Re: Mister Car Wash at 4703 Alameda Blvd NE
Erosion and Sediment Control Plan
Engineer's Stamp Date 6/21/24 (C17E002A26C)

Please accept the resubmittal addressing your review comments dated June 27, 2024.

C1.2B

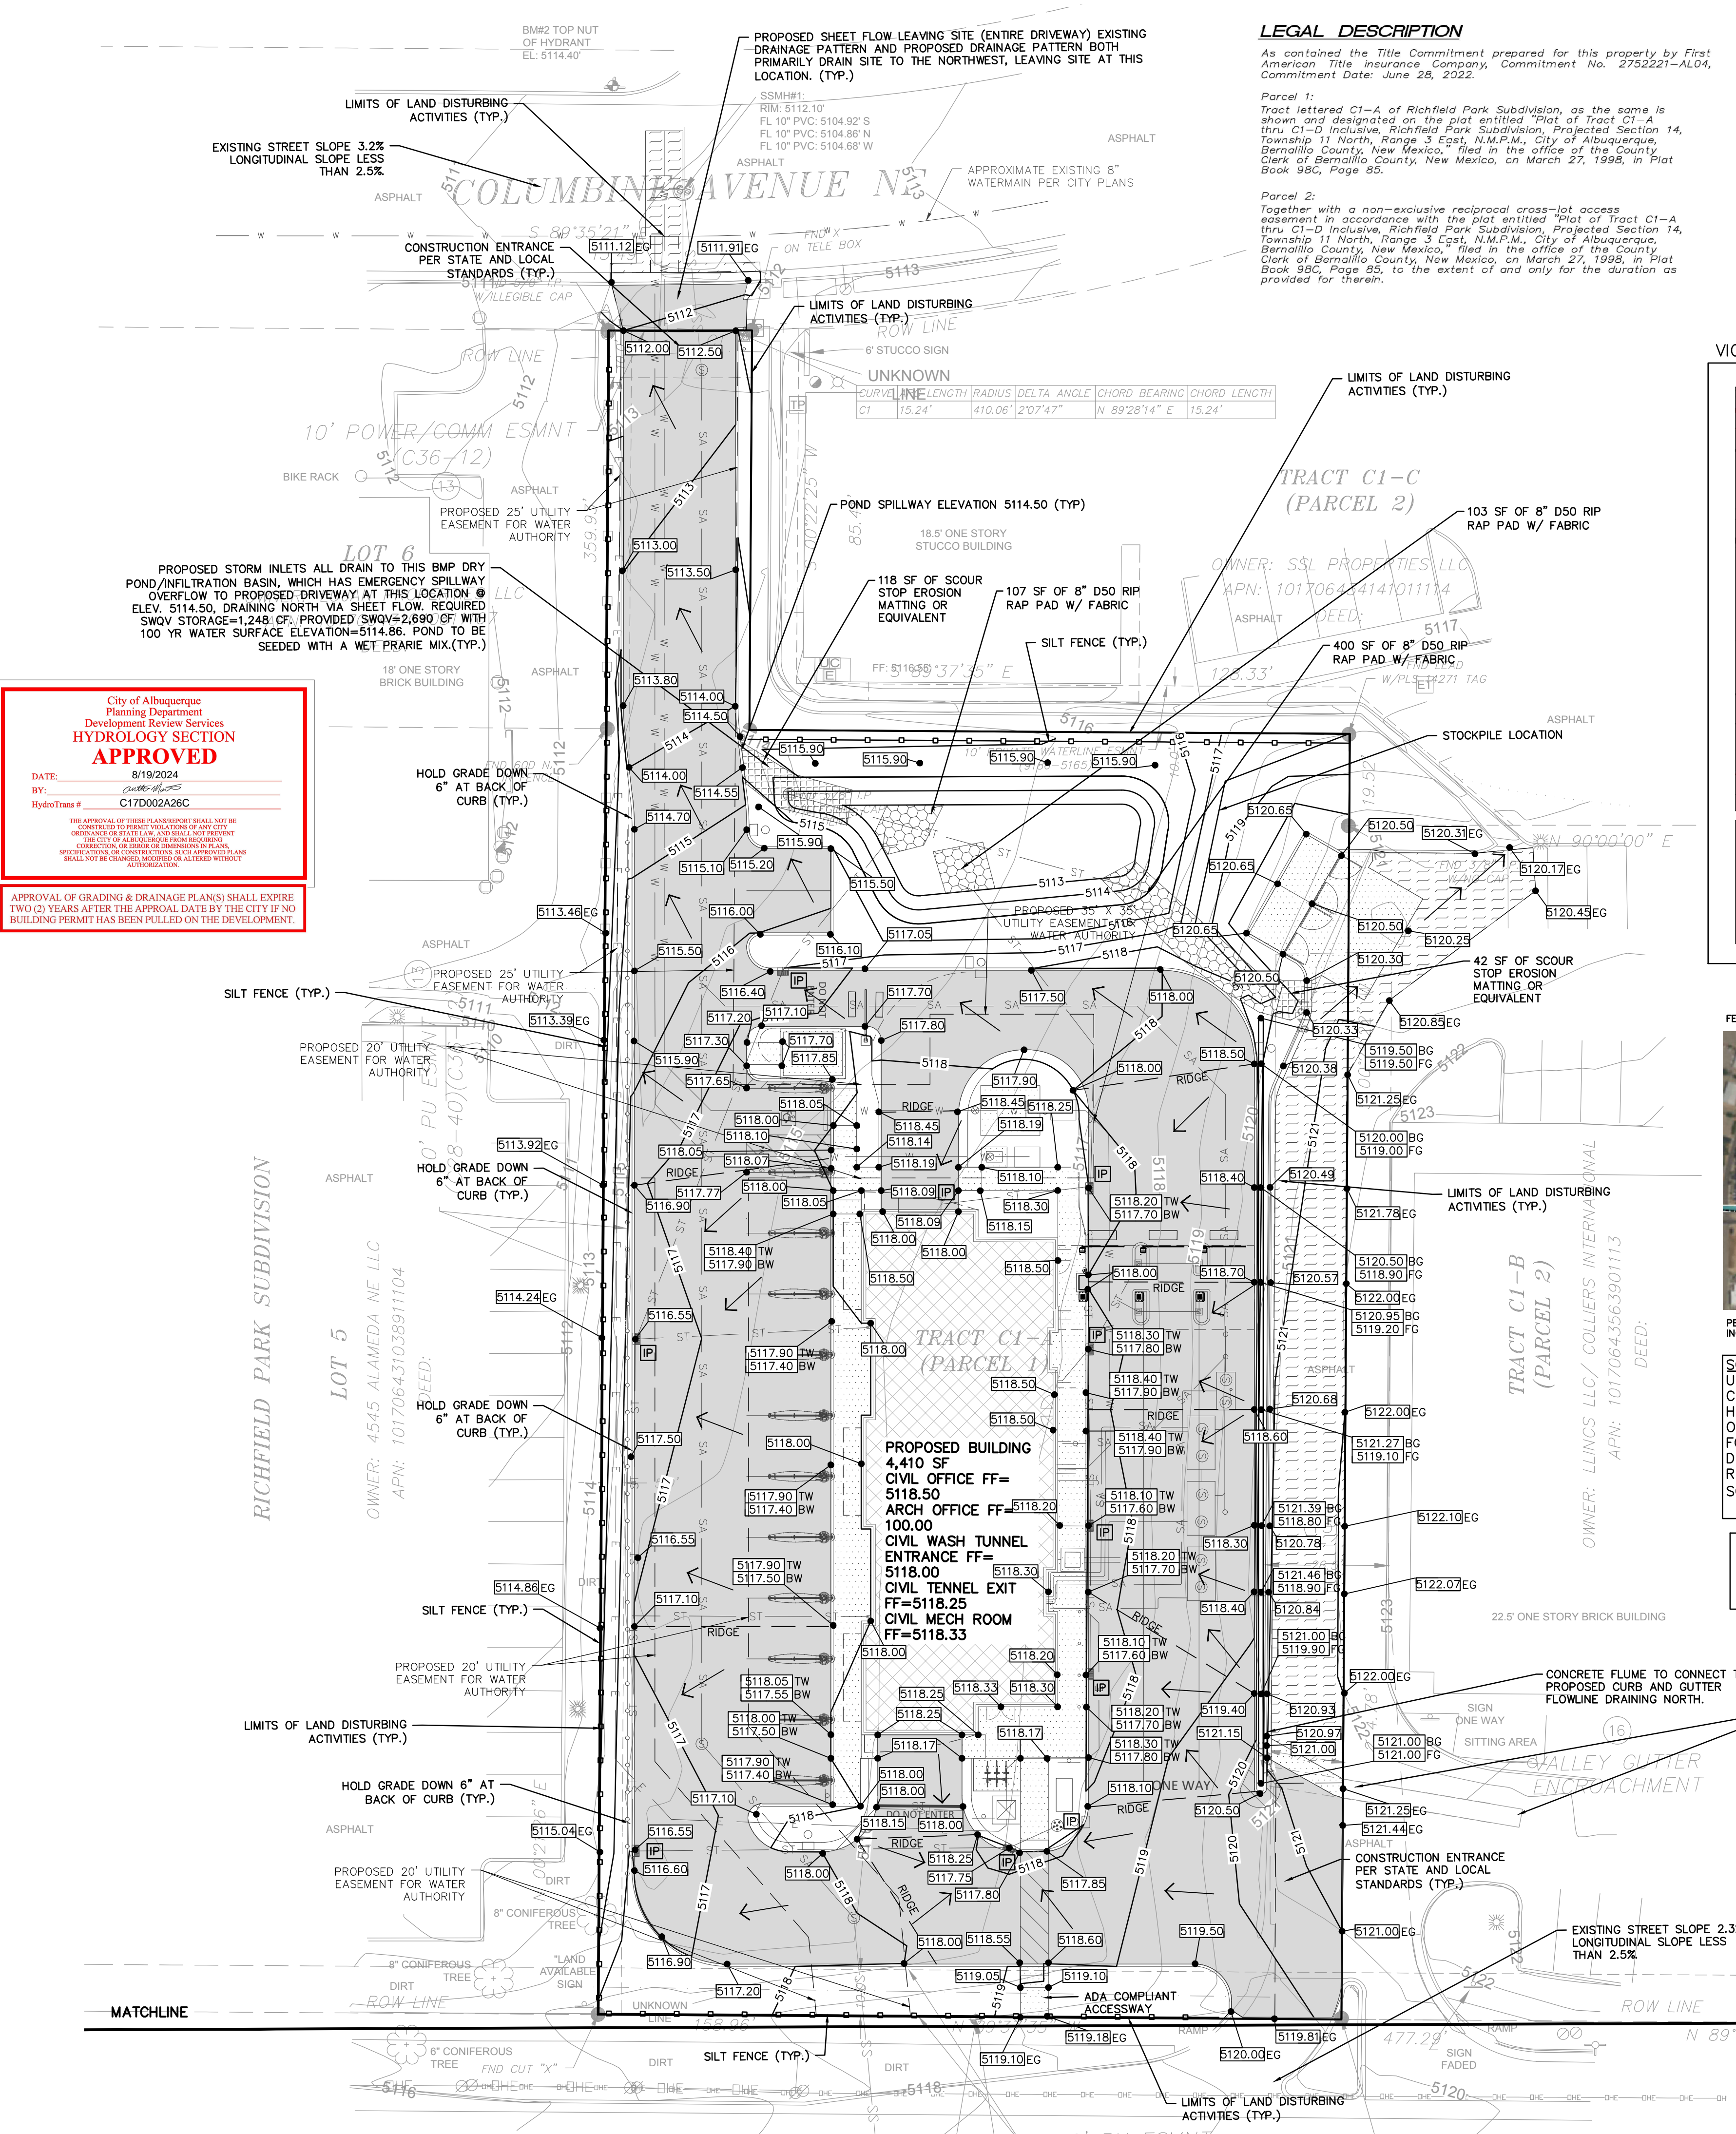
1. The ESC Plan can't be approved until after Hydrology approves the G&D Plan for each specific purpose, Site Plan, Grading, Building Permit, and Work Order. Hydrology has not yet approved the plan for any purpose. The existing and proposed grades must be shown on the ESC Plan, and they must agree with the Grading Plan approved by Hydrology (CGP7.2.4.b.ii);
Excel Response: Hydrology has now approved the plans. See included approval.
